# CITY OF ALBUQUERQUE

April 10, 2023

**Re: Building Addition**  
**3400 Columbia Dr. NE**  
**30-Day Temporary Certificate of Occupancy**  
**Transportation Development Final Inspection**  
Architect's Stamp dated 04-27-21 (G16-D139A)  
Certification dated 03-23-23

HC SIGN

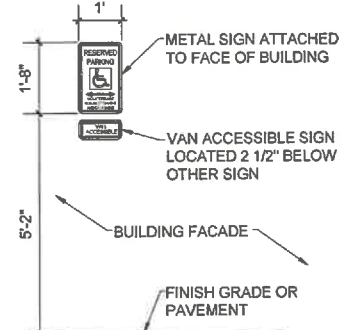
- Please provide a "Van" sign for one of the provided ADA parking spaces.
- The pavement marking "MC" should be shown in the opposite direction for Motorcycles entering the parking space.
- Per approved site plan, please build the site access's drivepad per city std 2425.
- Please fix or replace all the broken and cracked sidewalk, as mentioned in the general note on the approved site plan.
